EL PASO COUNTY STORMWATER MANAGEMENT PLAN CHECKLIST

EPC Project Number:

Applicant	EPC
17	SWMP Map to include: reviewed GEC Plan_v1		
17a	construction site boundaries		Y
17b	flow arrows to depict stormwater flow directions		Y
17c	all areas of disturbance		Y
17d	areas of cut and fill		Y
17e	areas used for storage of building materials, soils (stockpiles) or wastes		Y
17f	location of any dedicated asphalt / concrete batch plants		N
17g	location of all structural control measures		Y
17h	location of all non-structural control measures		Y
17i	springs, streams, wetlands and other surface waters, including areas that require maintenance of pre-existing vegetation within 50 feet of a receiving water		Y
18	Narrative description of all structural control measures to be used. Modifications to EPC standard control measures must meet or exceed County-approved details		Y
19	Description of all non-structural control measures to be used including seeding, mulching, protection of existing vegetation, site watering, sod placement, etc.		Y

GRADING & EROSION CONTROL PLAN

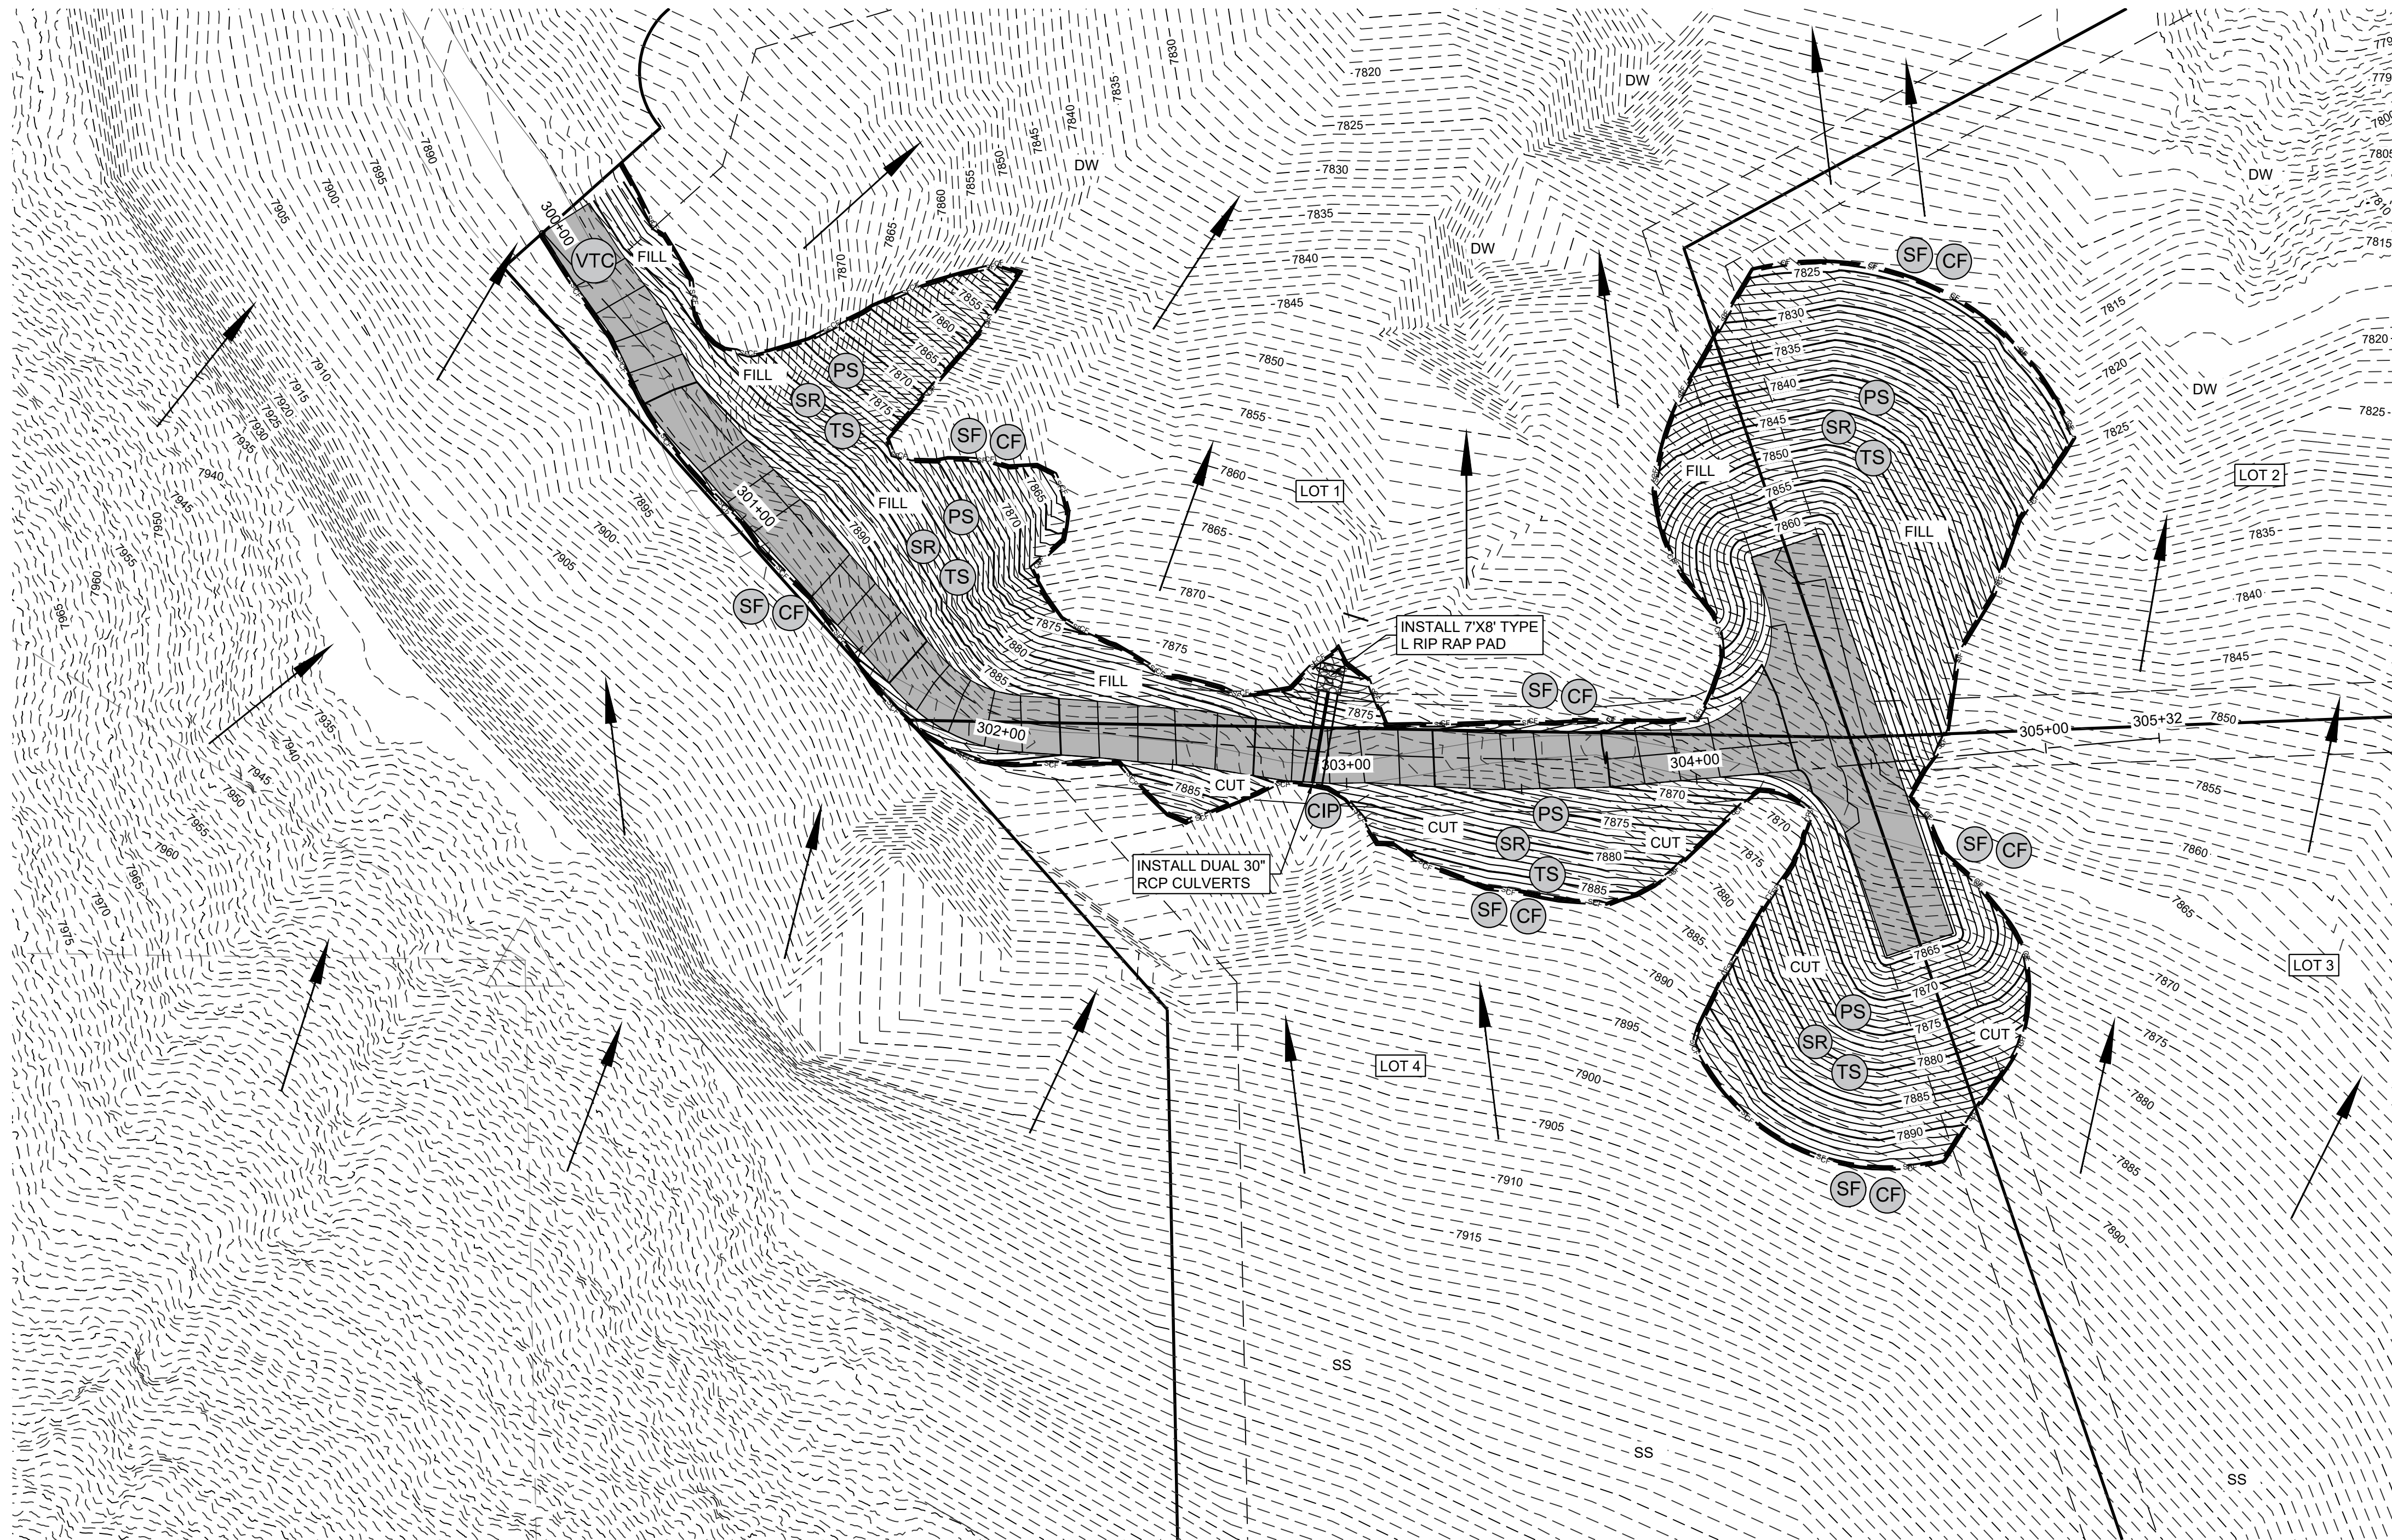
Don't use N/A. Also see comments regarding batch plants on the GEC Plan.
